Application Ref:	2023/0309				Ribble Valley Borough Council www.ribblevalley.gov.uk
Date Inspected:	12/05/2023	Site Notice:	12/05/2023		
Officer:	Will Hopcroft				
DELEGATED ITEM FILE REPORT:					REFUSAL

Development Description:	Proposed installation of external illuminated fascia sign and external illuminated hanging sign.
Site Address/Location:	57 Berry Lane, Longridge

**Drawing :** Proposed Signage Elevations

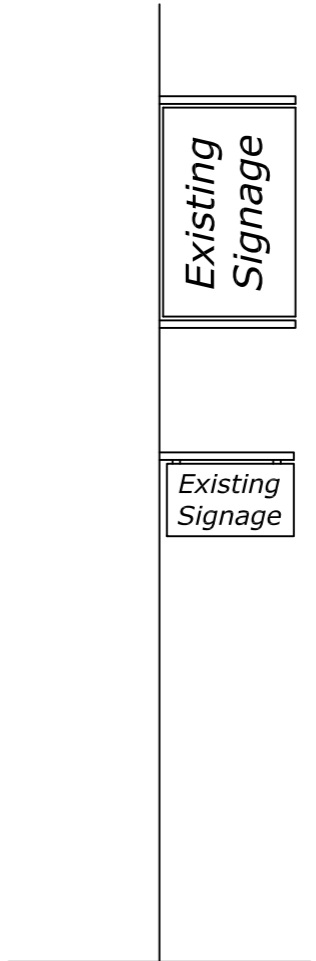
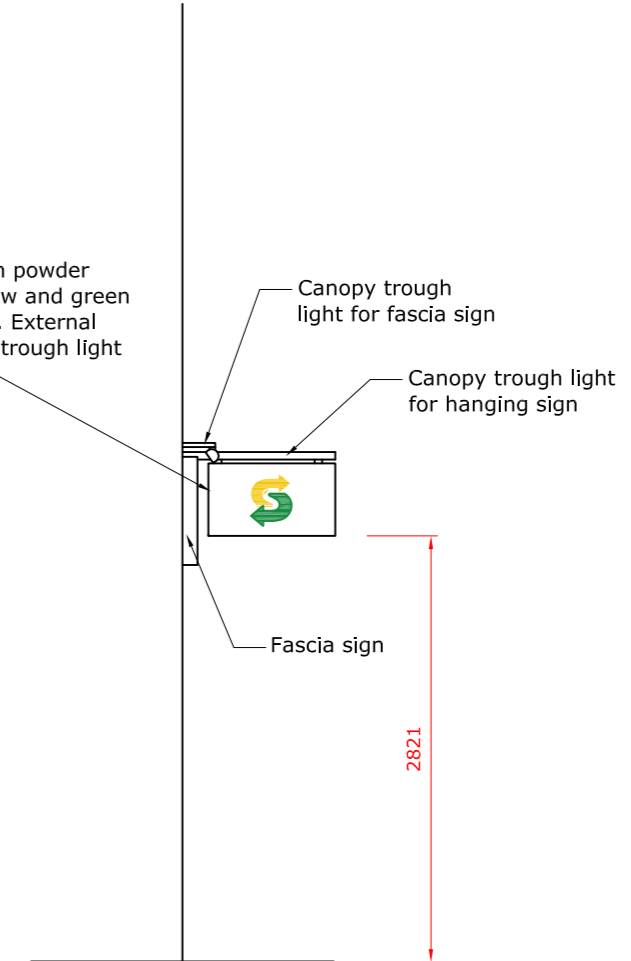
The proposal itself would seek to replace the traditional, wooden painted existing signage with a bulky and intrusive aluminium fascia powder coated white sign. This is more visually intrusive both in terms of height, width and depth, with the bright white illuminated colour dominant in the existing streetscene out of keeping with the style of adjacent advertisements. Furthermore, the width of the sign is far greater than that of the existing, in which the signs were effectively broken up into 3 separate signage sections and utilised a good level of bordering to ensure the advertisements were not dominant and did not cause a visual detriment to the streetscene. With the proposed advertisement, there is no obvious 'break' and no reflection of the existing, traditional shopfront layout and when combined with similar width and dominance of the adjacent proposed signage at 53-55 Berry Lane, is dominant and incongruous to a point where there is less than substantial harm identified with regard to the Conservation Area.

In addition, the height of the letters is considered significant with the majority of adjacent advertisements utilising a more subtle lettering style. The style is evidently modern where the existing was traditional and this disparity is not congruous with the existing nature of the streetscene, even taking into account the existing consented advertisement in that section of Berry Lane.

Whilst the provision of an existing white hanging sign is noted, it is considered that the cumulative impact of replacing and illuminating the hanging sign to match the fascia sign would contribute to the less than substantial harm.

With regard to the materiality, the provision of illuminated powder coated aluminium is not deemed congruous with the existing streetscene and is not complementary or preservative of the character and

significance of the existing front elevation, which appears to be painted wooden signs which are more reflective and complementary of the traditional nature of the shopfronts.

| 01: | The proposal would result in inappropriate, incongruous and visually intrusive advertisements that would cause less than substantial harm to the significance of the Conservation Area, with very little public benefit identified. As such the proposal fails the test outlined in NPPF Paragraph 202 and is not compliant with Key Statement EN5, Core Strategy Policies DME4, DMG1 or Longridge Neighbourhood Plan Policy LNDP4. |
